DATE: August 9, 2019  
TO: Kari Parsons, PCD-Project Manager  
FROM: Kyle R. Campbell, P.E. – Division Manager  
SUBJECT: Response to “**SF-19-007– Midtown Collection at Hannah Ridge Filing 1 First Submittal**”, dated May 9, 2019

MIDTOWN COLLECTION AT HANNAH RIDGE
 FILING NO. 1
 OVERLOT GRADING AND EROSION CONTROL PLAN

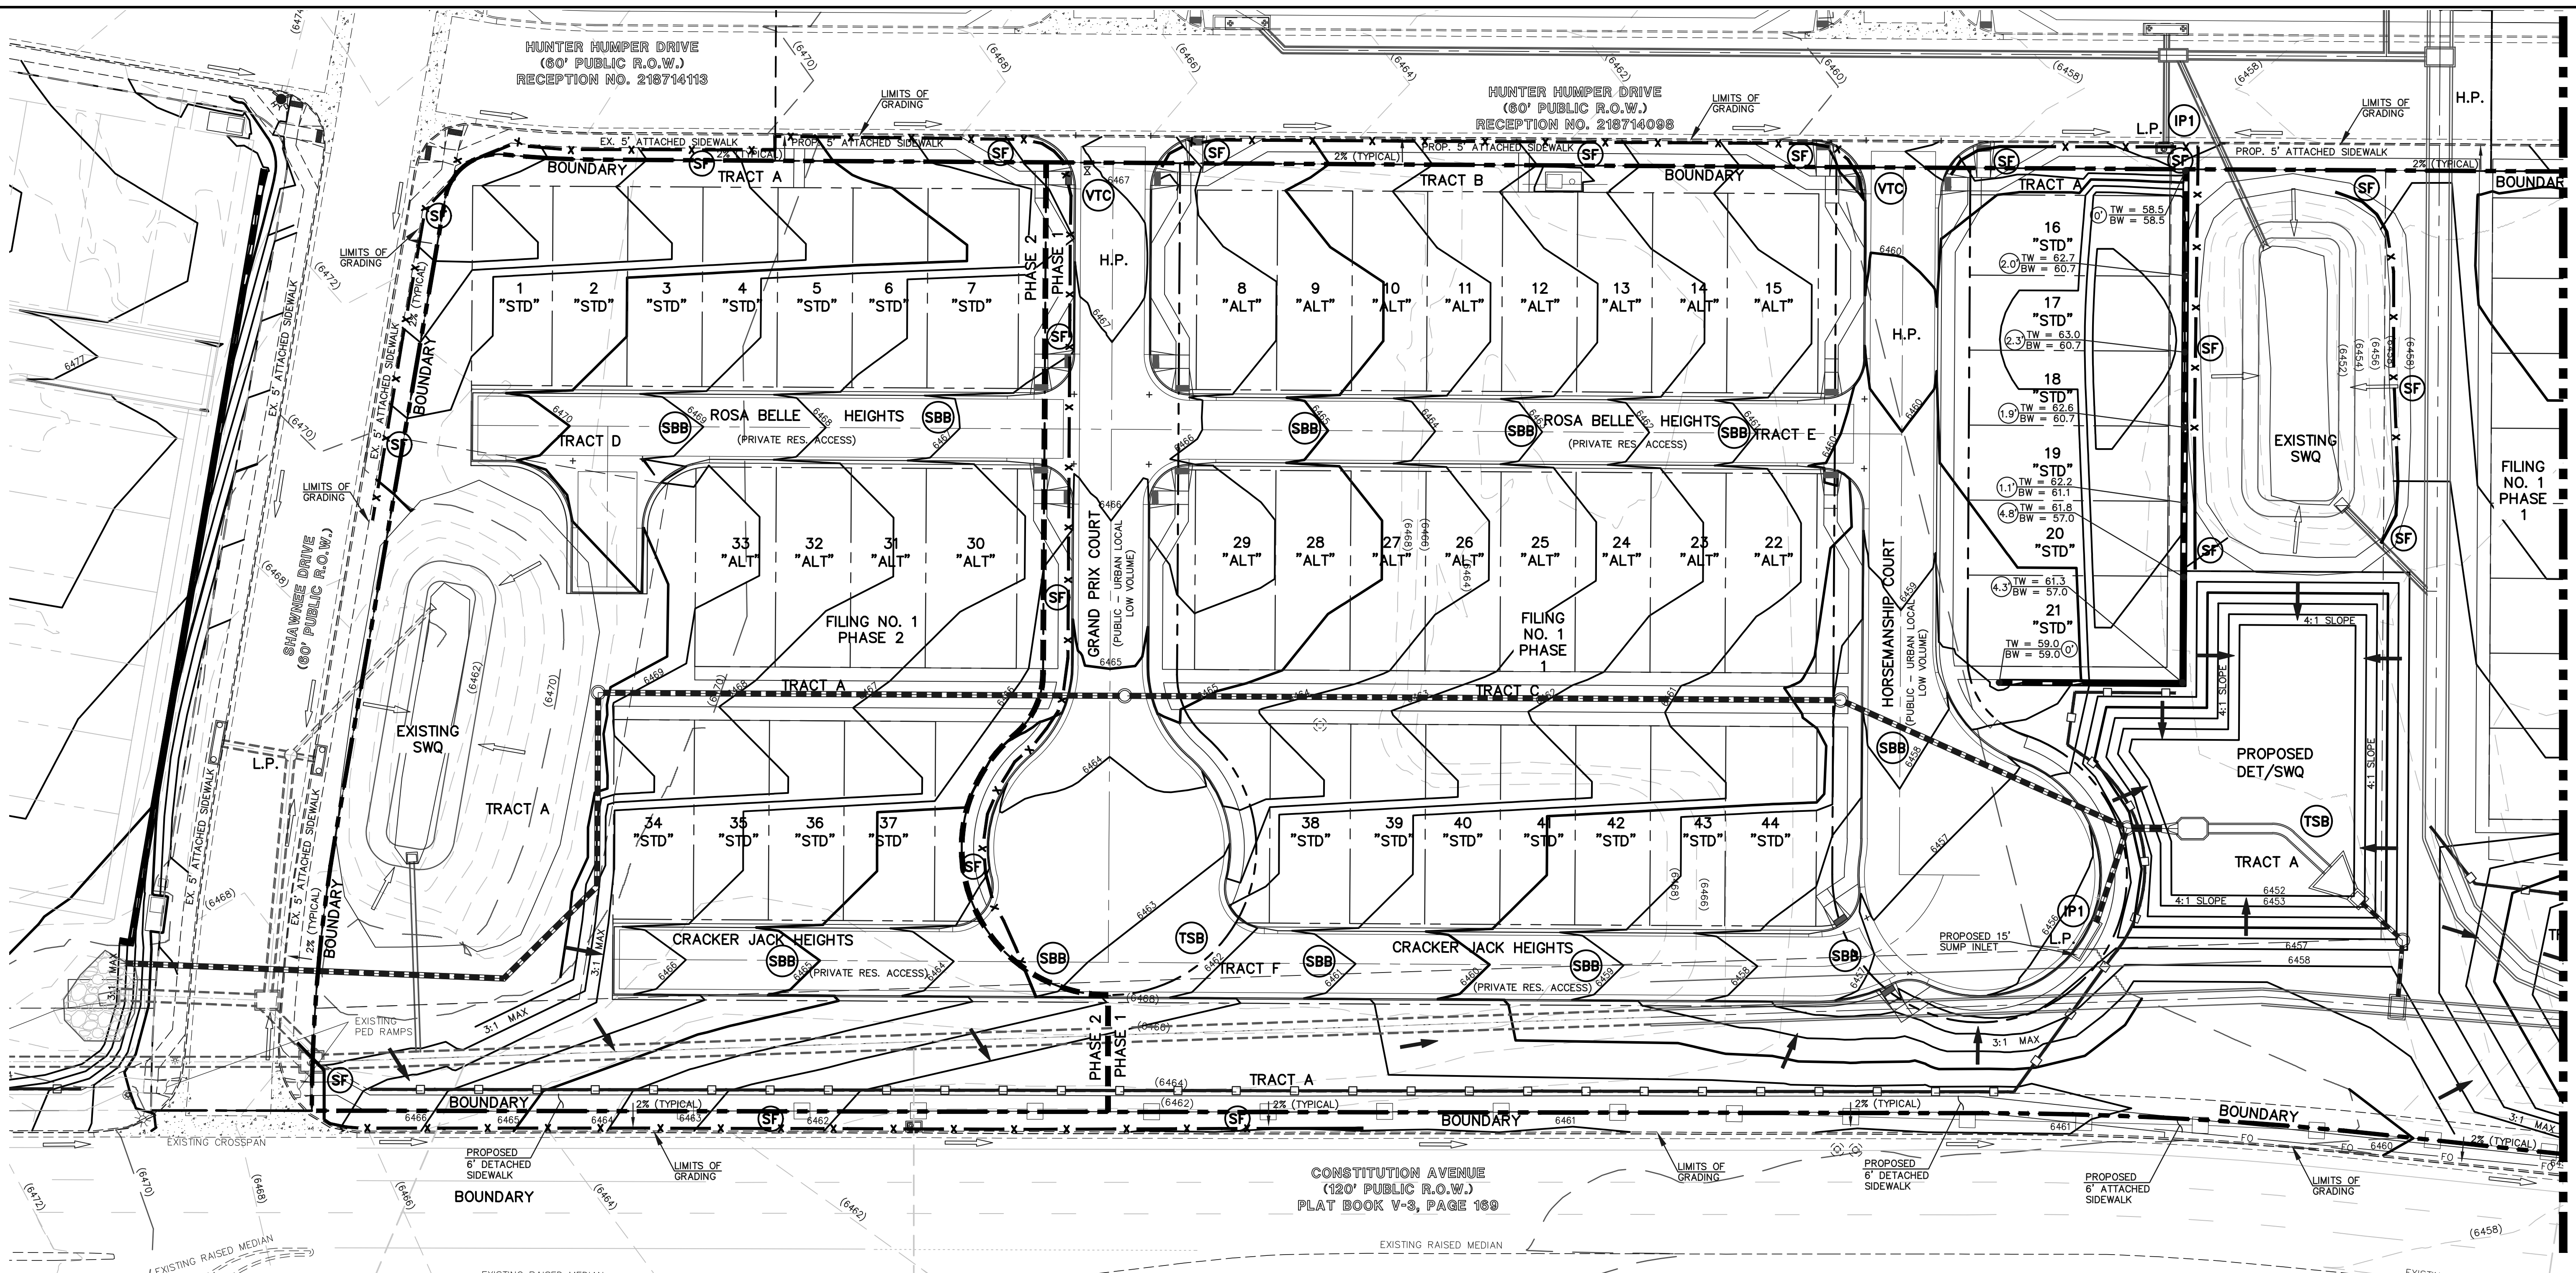
3. If there will be USPS mail kiosk/cluster in this subdivision provide location and details.  
**RESPONSE: Shown on plans.**
4. Ensure that all GEC Plan and SWMP checklist items (attached) are provided. GEC and SWMP checklists will be reviewed further with the next submittal. There generally appears to be an insufficient amount of sediment controls shown on these plans; more controls such as temporary sediment basins, silt fence or wattles, and concrete wash out areas need to be provided.

**RESPONSE: See revised.**

MIDTOWN COLLECTION AT HANNAH RIDGE
FILE NO. 1
STREET IMPROVEMENT PLANS
JAZZY LADY COURT / HORSEMANSHIP COURT

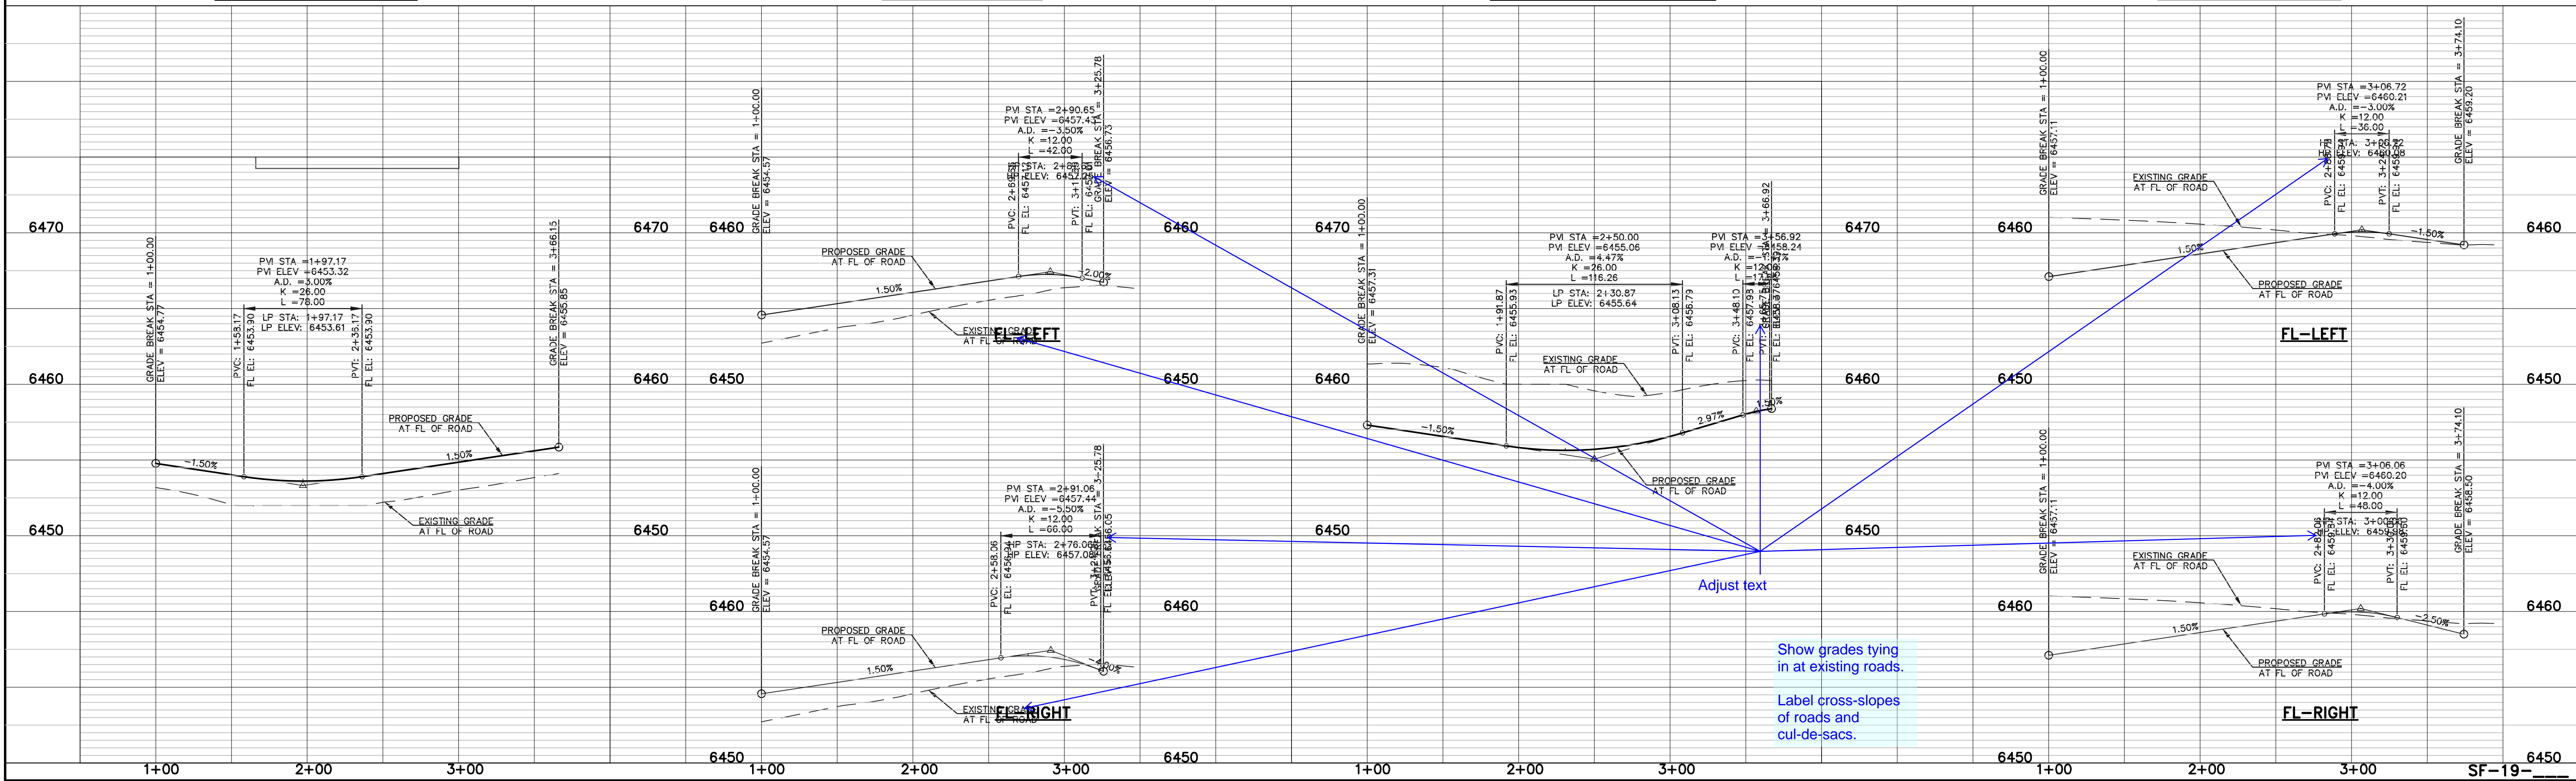
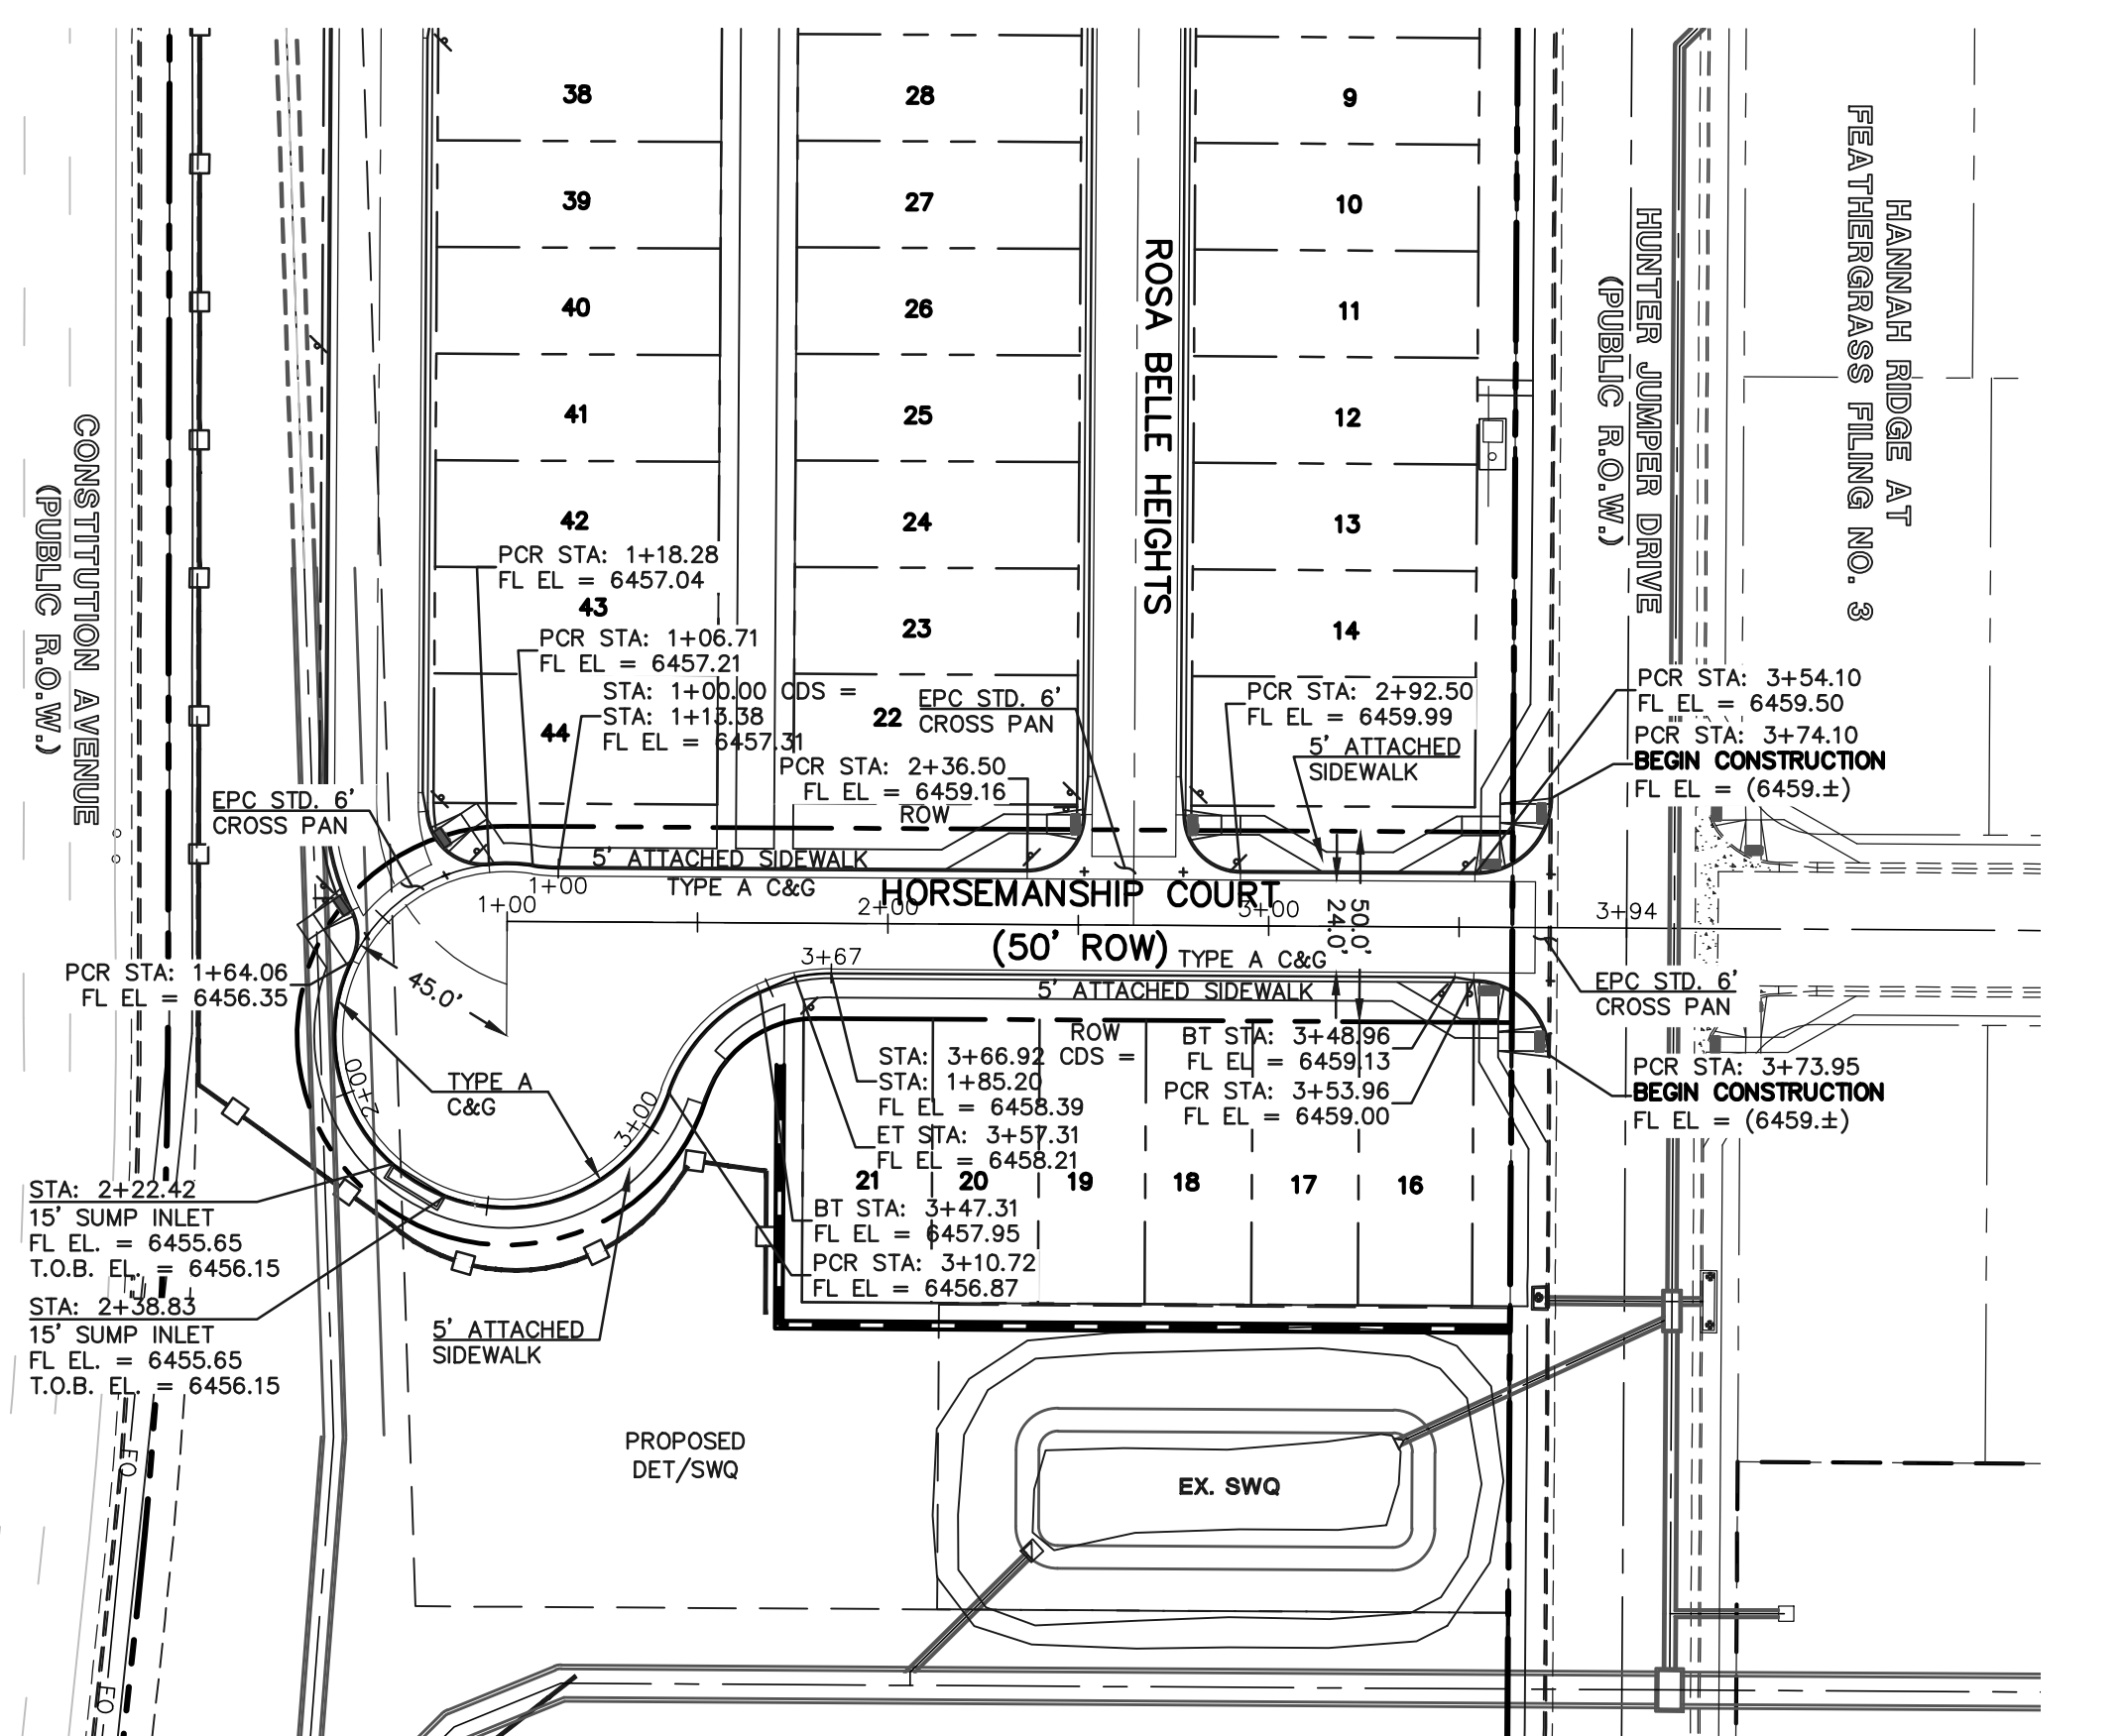
1. Assess the need for signage at the entrances and ends of the cul-de-sacs (W14-1/W14-2 and Type 4 object markers?).  
**RESPONSE: See revised plans.**
